TR010060 " A12 Chelmsford to A120 widening scheme

Mary Ann Lindsay and John Chilcott Lindsay

Unique reference nos.: A12C-AFP653 and A12C-AFP654 Columbyne Cottage, Kelvedon Road, Inworth. CO5 9SH Title number EX525948

This submission is supplemental to our previous representations submitted in October 2022.

Drawing Title ENVIRONMENTAL STATEMENT NOISE STUDY AREAS, NOISE IMPORTANT AREAS AND NOISE MONITORING LOCATIONS SHEET 1 OF 1						
Drawing Status S4 - SUITABLE FOR STAGE APPROVAL						
Scale @ A3		1:70000	DO NOT SCALE			
Jacobs No.		B36601D1	Rev P01			
Client No.		HE551497

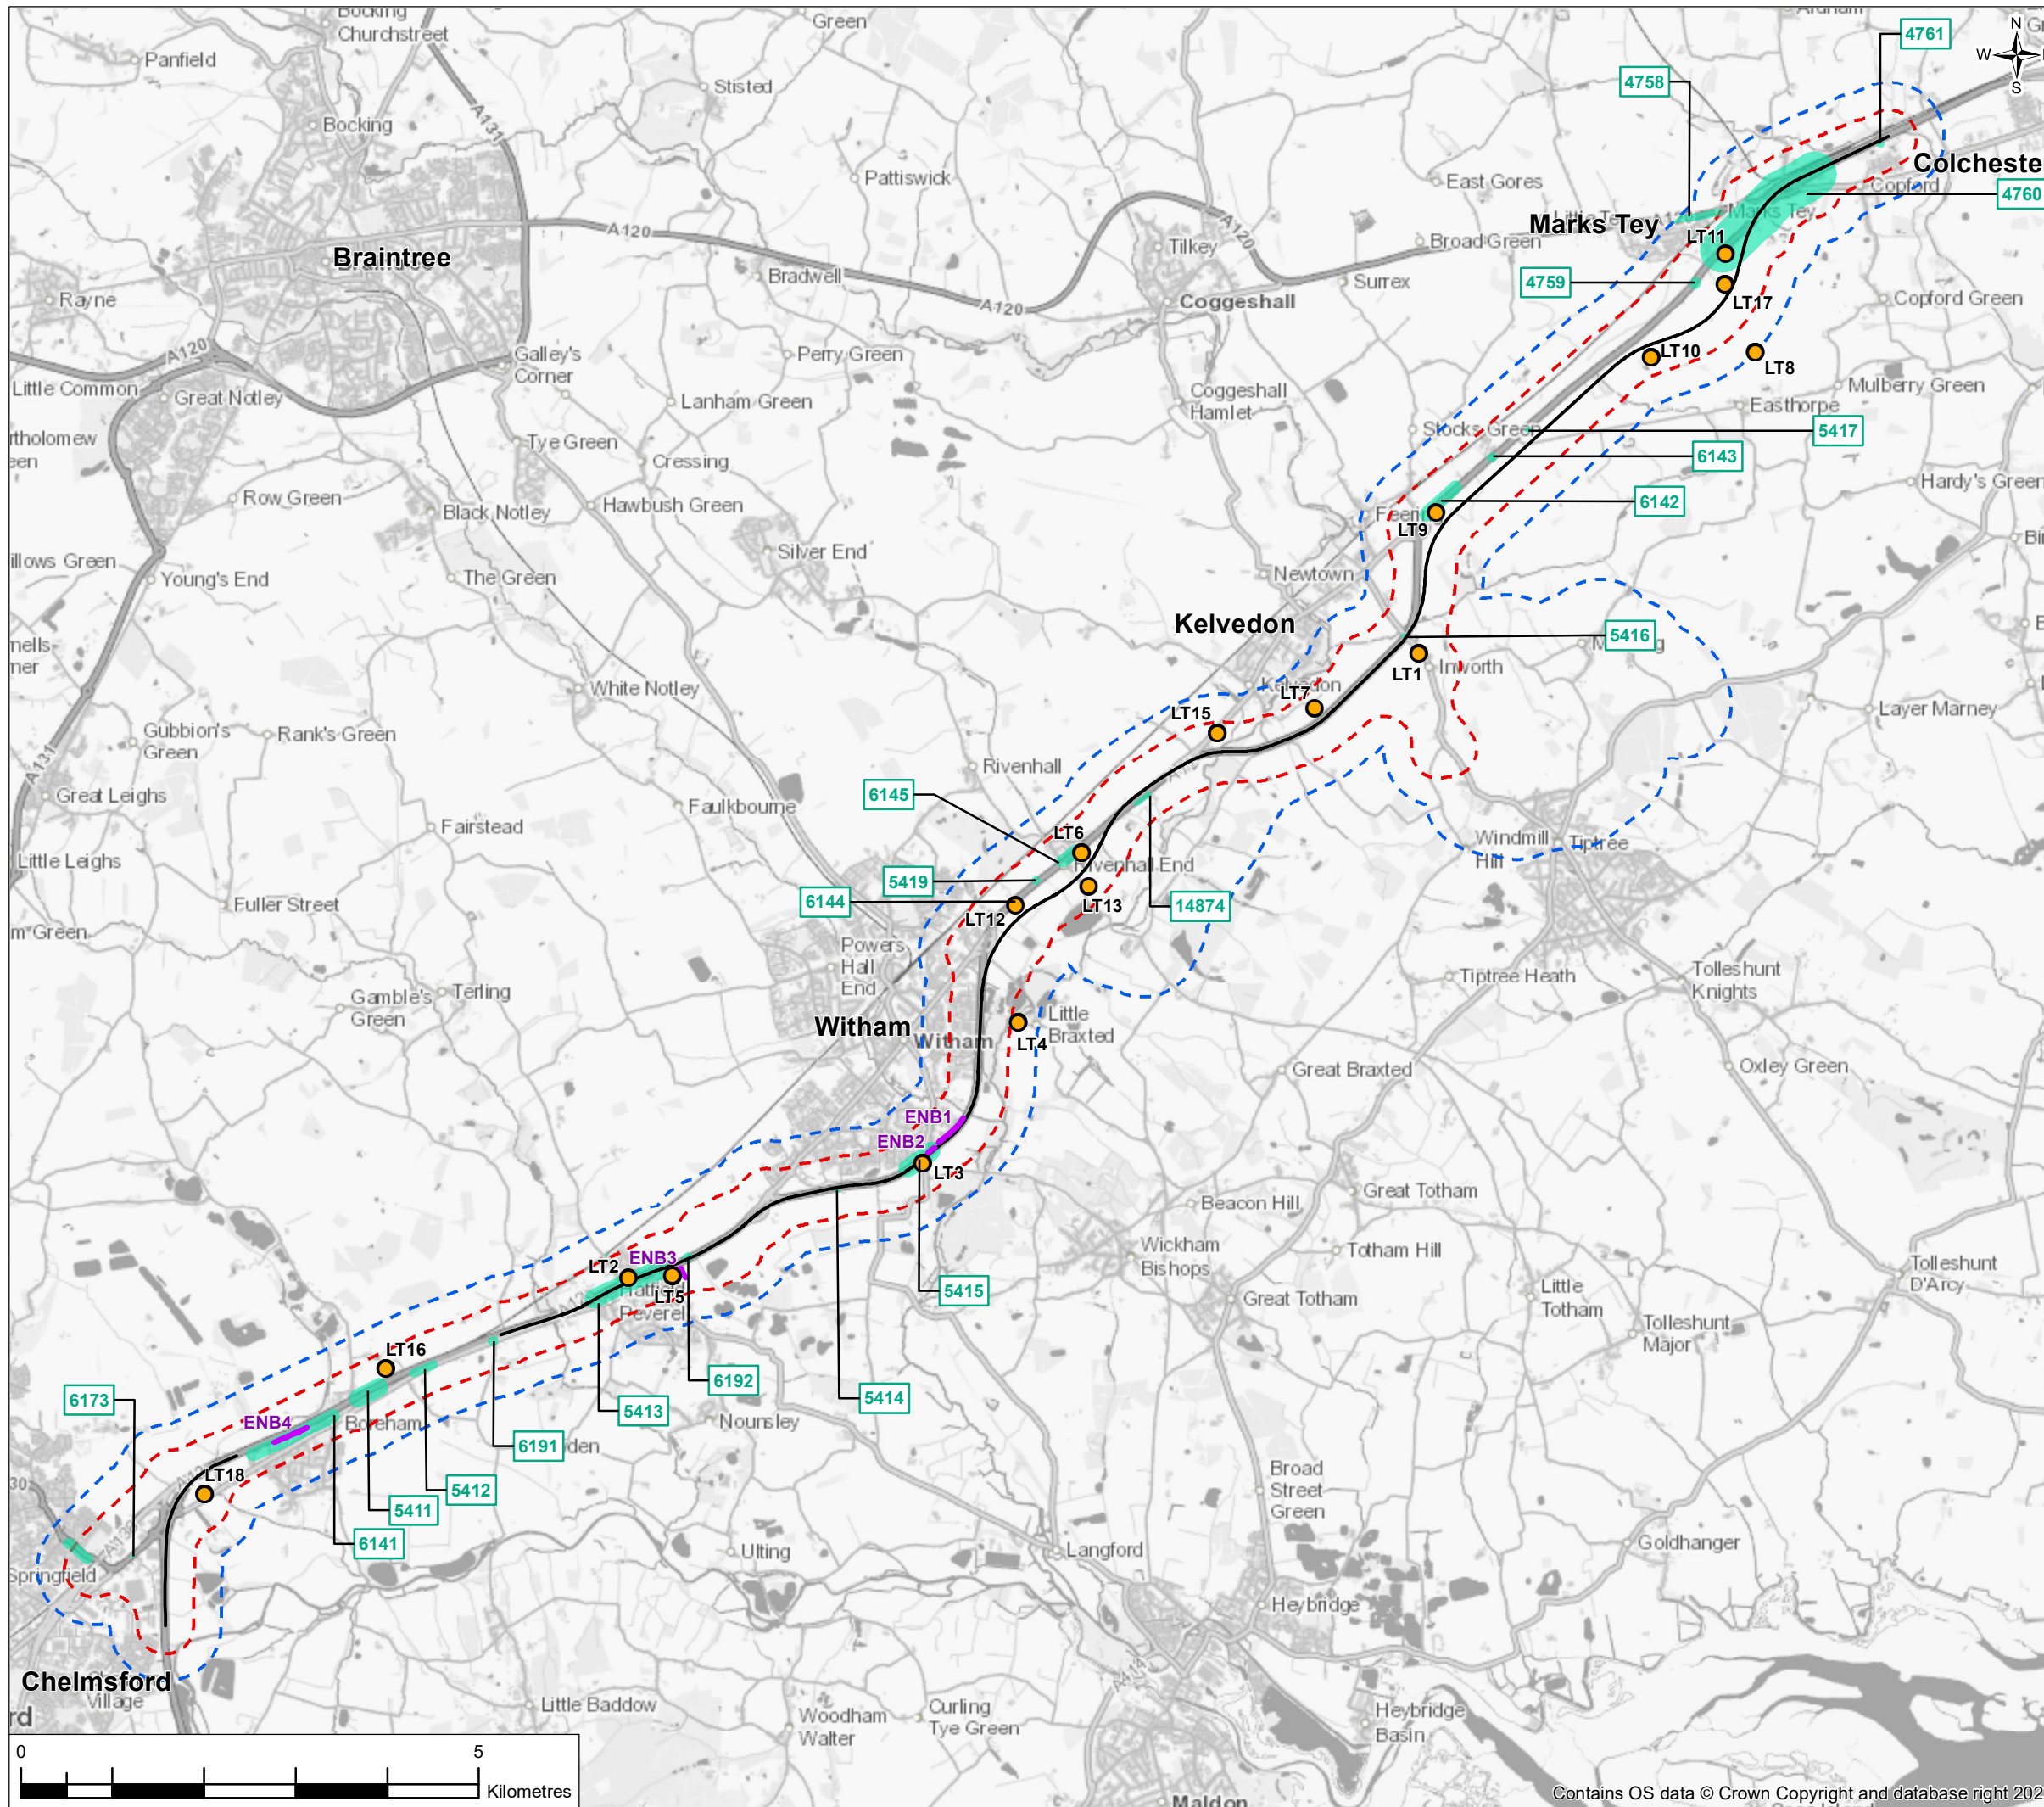
We are concerned about increased noise from the A12 when it has been widened. Some parts of the new A12 will have "Low noise surface" but the section near us appears not to have this.

We request that the Inspector requires NH to ensure that the A12 in the area of Junction 24, together with this section of the new Kelvedon Bypass, are also constructed with the "Low Noise Surface with enhanced noise reducing properties."
